**RE: 6/2020/1181/COND – Northaw House, Coopers Lane, Northaw, Potters Bar, EN6 4NG**

Thank you for consulting us on the above application for the submission of details pursuant to condition 1 (surface water drainage scheme) on planning permission 6/2019/0217/MAJ at Northaw House, Coopers Lane, Northaw, Potters Bar, EN6 4NG.

We have reviewed the covering note and appendices prepared by Civilistix reference DRM/CIV/1-046 dated May 2020 submitted in support of this application.

DRAWING TITLE: **PROPOSED POND SECTIONS**

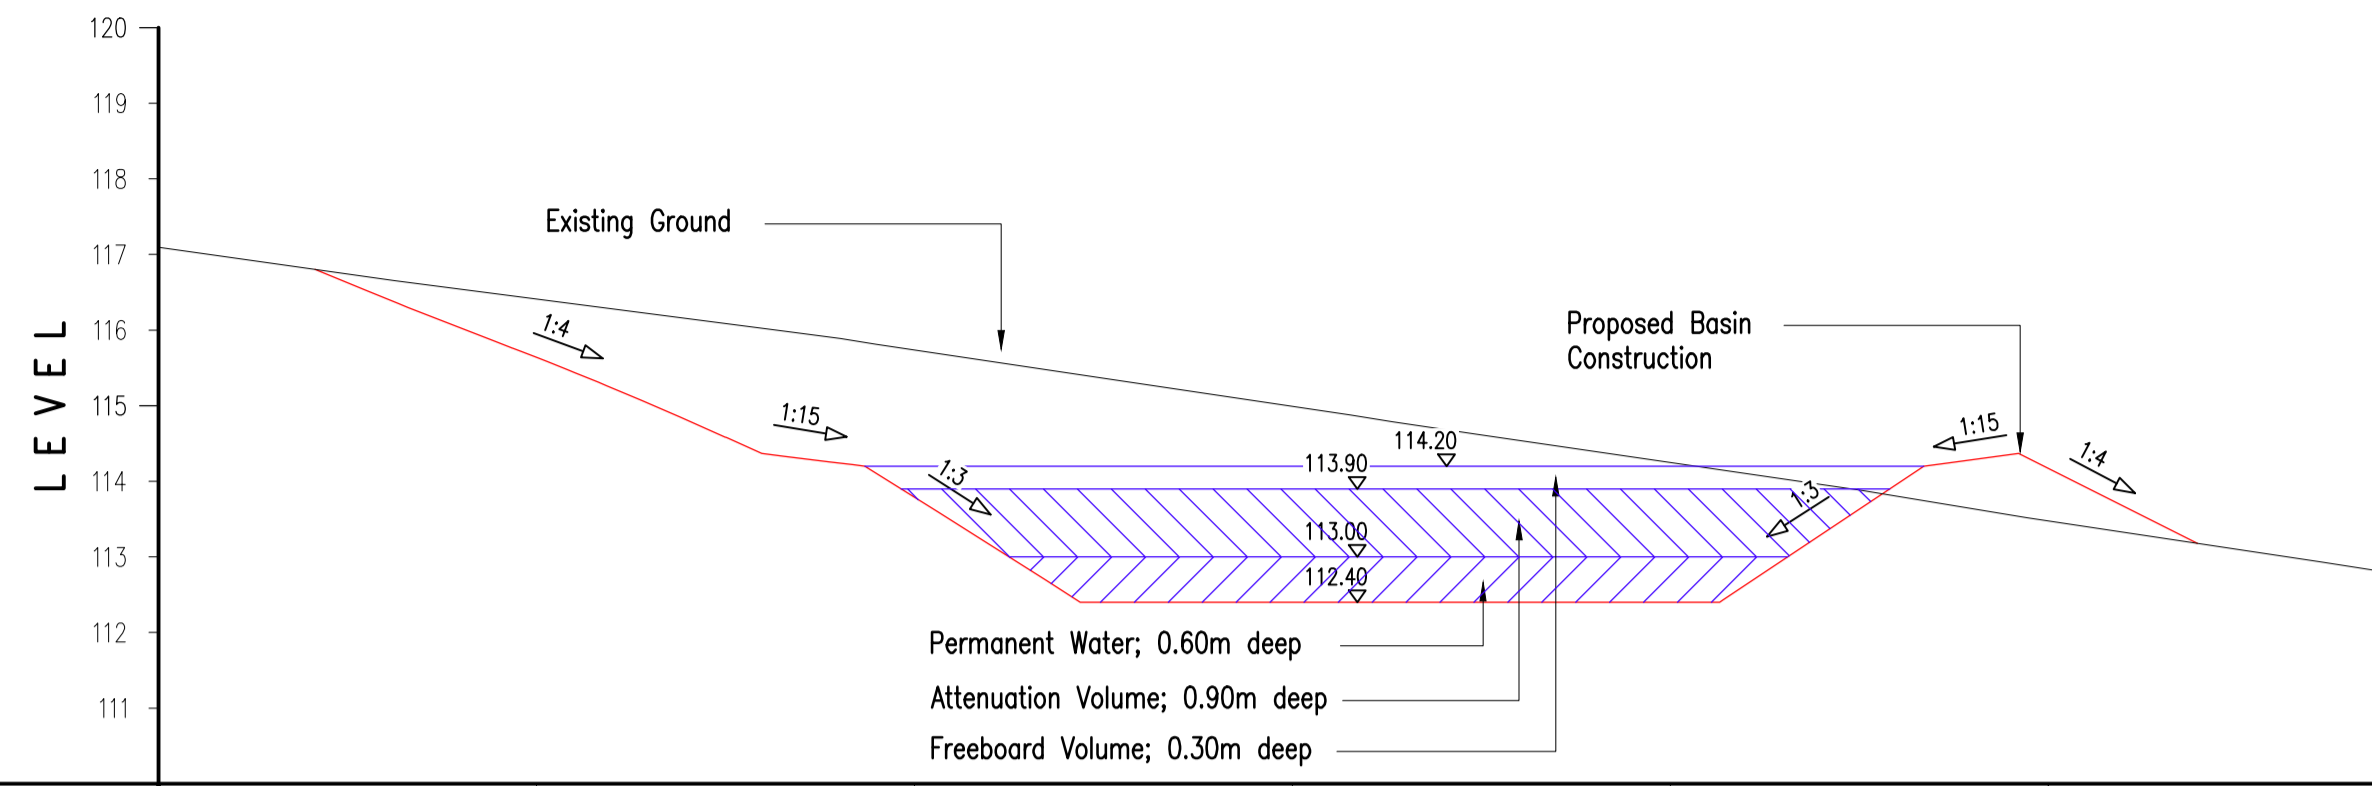
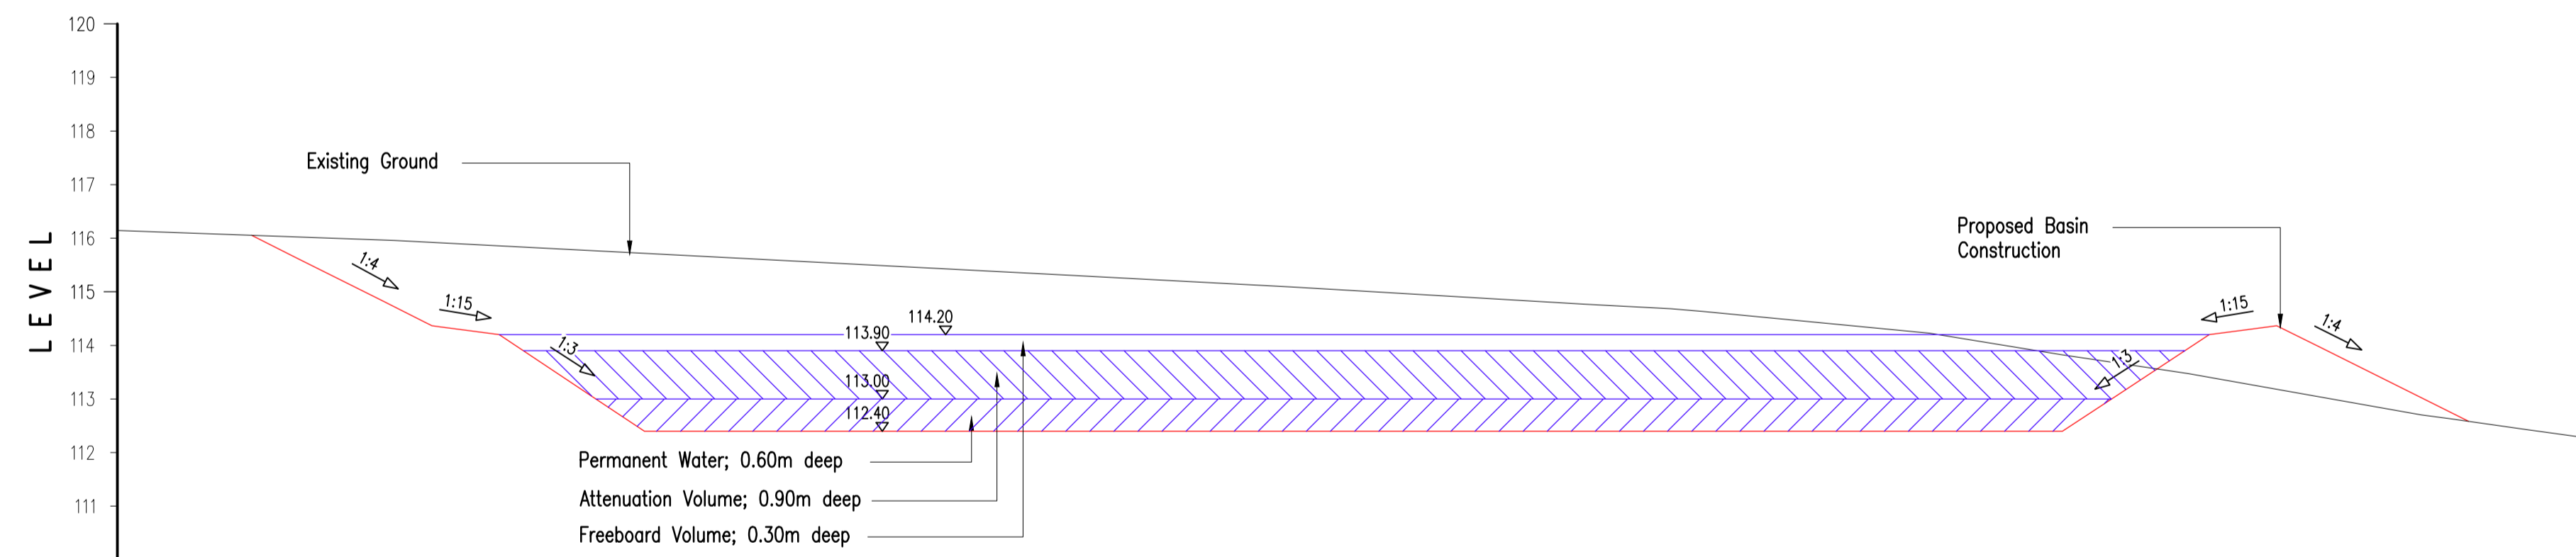
The applicant has provided calculations for the 1 in 100 year + 40% climate change event including half drain down times for the attenuation basin. However, we note that half drain down time is 30.10 hours. We require half drain down times no greater than 24 hours. The applicant should therefore seek to provide detailed calculations demonstrating the system will manage for all storm events up to and including the 1 in 100 year + 40% climate change storm including half drain down times no greater than 24 hours. As a minimum, the applicant should demonstrate that the drainage system is designed to manage for the 1 in 100 year + climate change event followed by a 1 in 30 event within 24 hours.
